24 January 2018

Our Ref: Case 169040

Re: Alexandria Park Community School Redevelopment, Park Road, Alexandria (SSD 8373)

Figure 3: Location of Sydney Water Easement

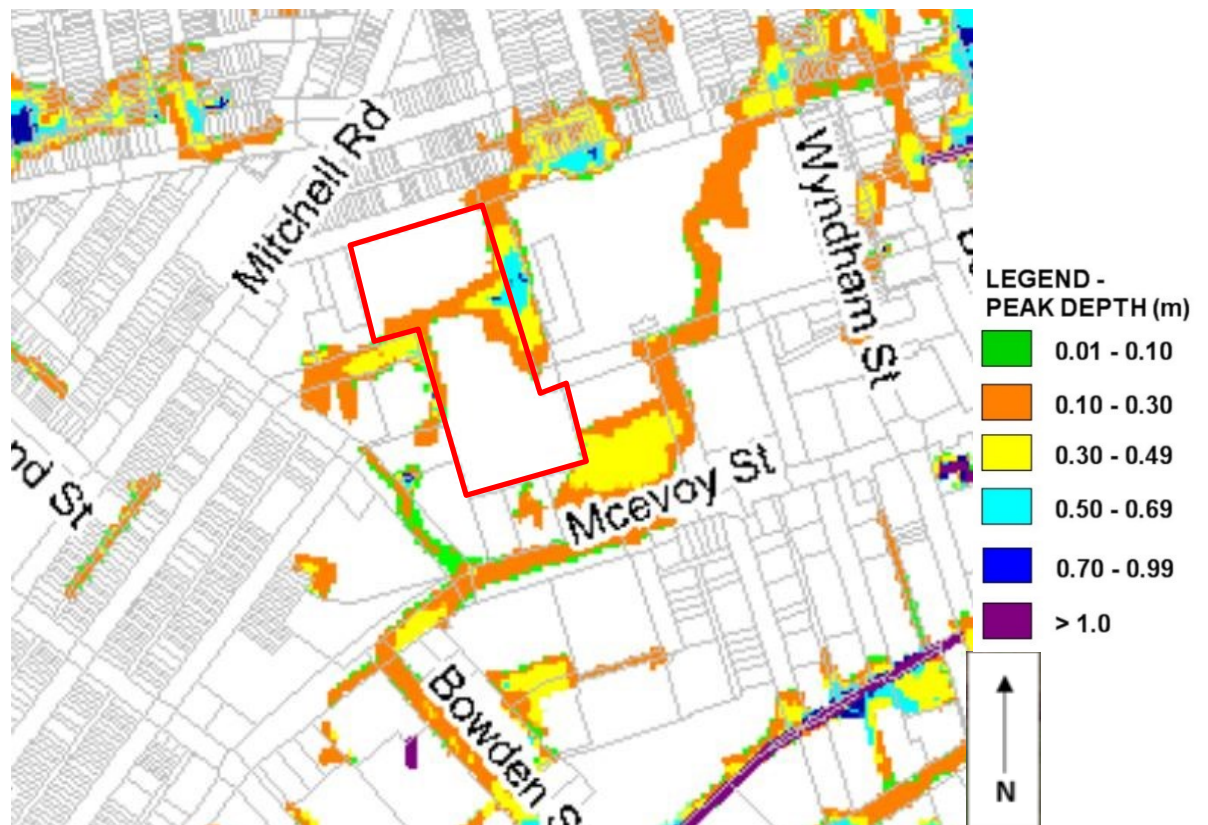
Sydney Water **objects** to the current proposal as it does not comply with the Sydney Water's guidelines for Building Over or Adjacent to Stormwater Assets.

- No building or permanent structure is to be constructed:
 - over the stormwater channel/pipe or
 - within 1m from the outside wall of the stormwater asset or
 - within Sydney Water easement whichever is larger.
- Permanent structures include, but are not limited to: basement car park, hanging balcony, roof eaves, hanging stairs, stormwater pits, stormwater pipes, elevated driveway, basement access or similar structures. This clearance requirement would apply for unlimited depth and height.
- The applicant is required to submit the elevation drawings with the stormwater channel/ pipe/ Sydney Water easement, to ensure that the proposed buildings and permanent structures are **1m** away from the outside face of the stormwater channel, and away from the Sydney Water easement.
